From: Chris Westbury [REDACTED]
Sent: 30 March 2020 16:27
To: Planning
Cc: Nicola Moore
Subject: AW/84/20/CLP 18 Chalkmare Coppice Aldwick PO21 3SA
Attachments: PL01.pdf; PL06.pdf

Re: AW/84/20/CLP 18 Chalkmare Coppice Aldwick PO21 3SA

PROPOSED NORTH WEST ELEVATION @ 1:100

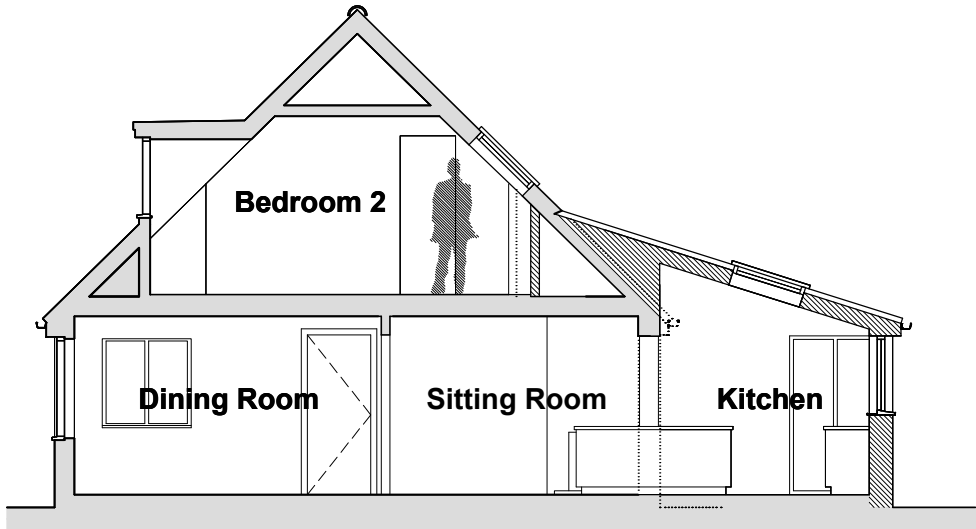
With regard to point 3 I have checked the drawings and the window in the garage on the NW elevation is shown on plan for both the existing and proposed plans?

SCALE:	As shown @ A3	
DATE:	Jan 2020	
DRAWN:	ASW	
CHECKED BY:	CW	
DRAWING NO:		
N320	PL01

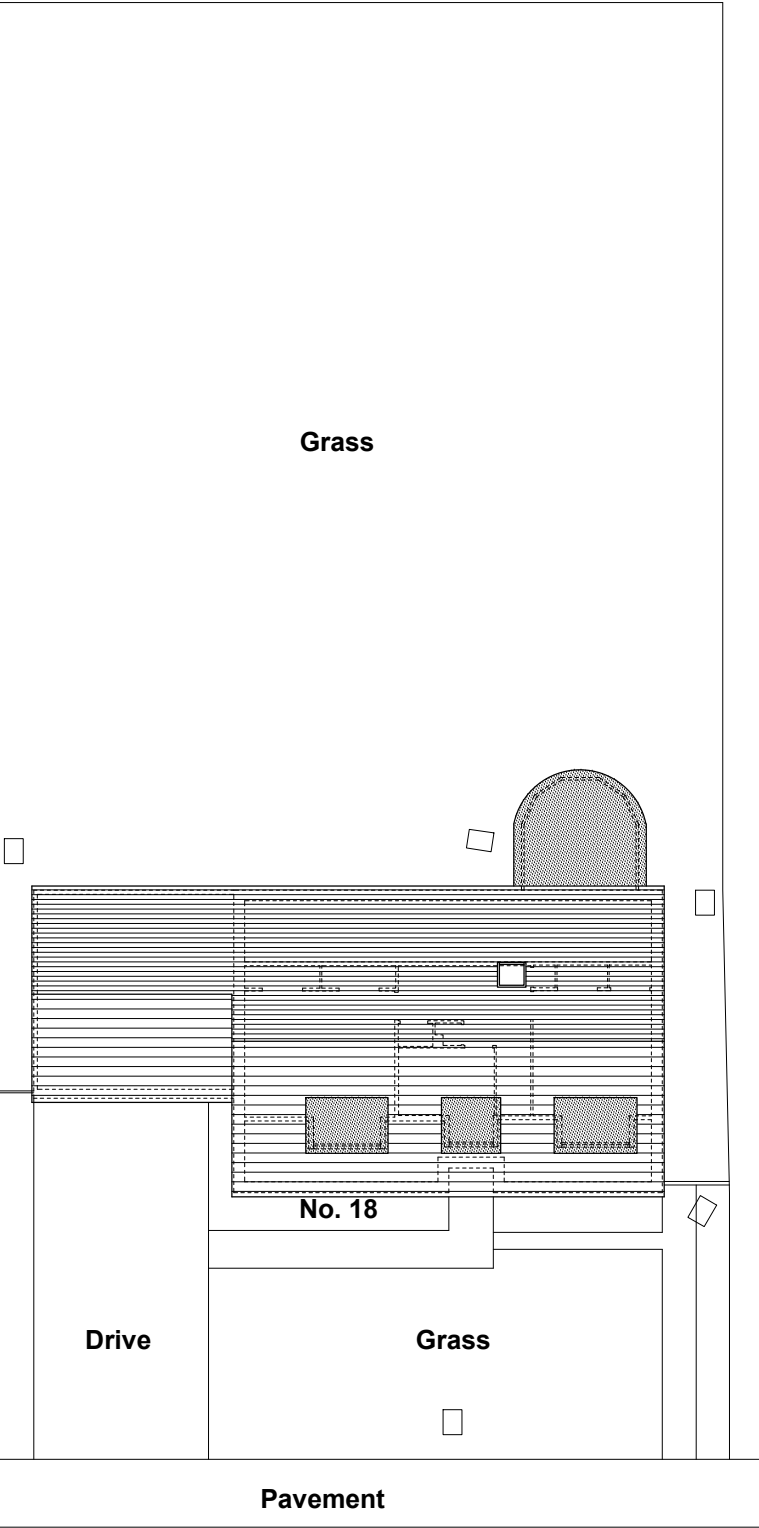
I have attached updated drawings as follows;
PL01 – Dimensions added to show distance from boundaries.
PL06 – New window to garage added to NE Elevation.
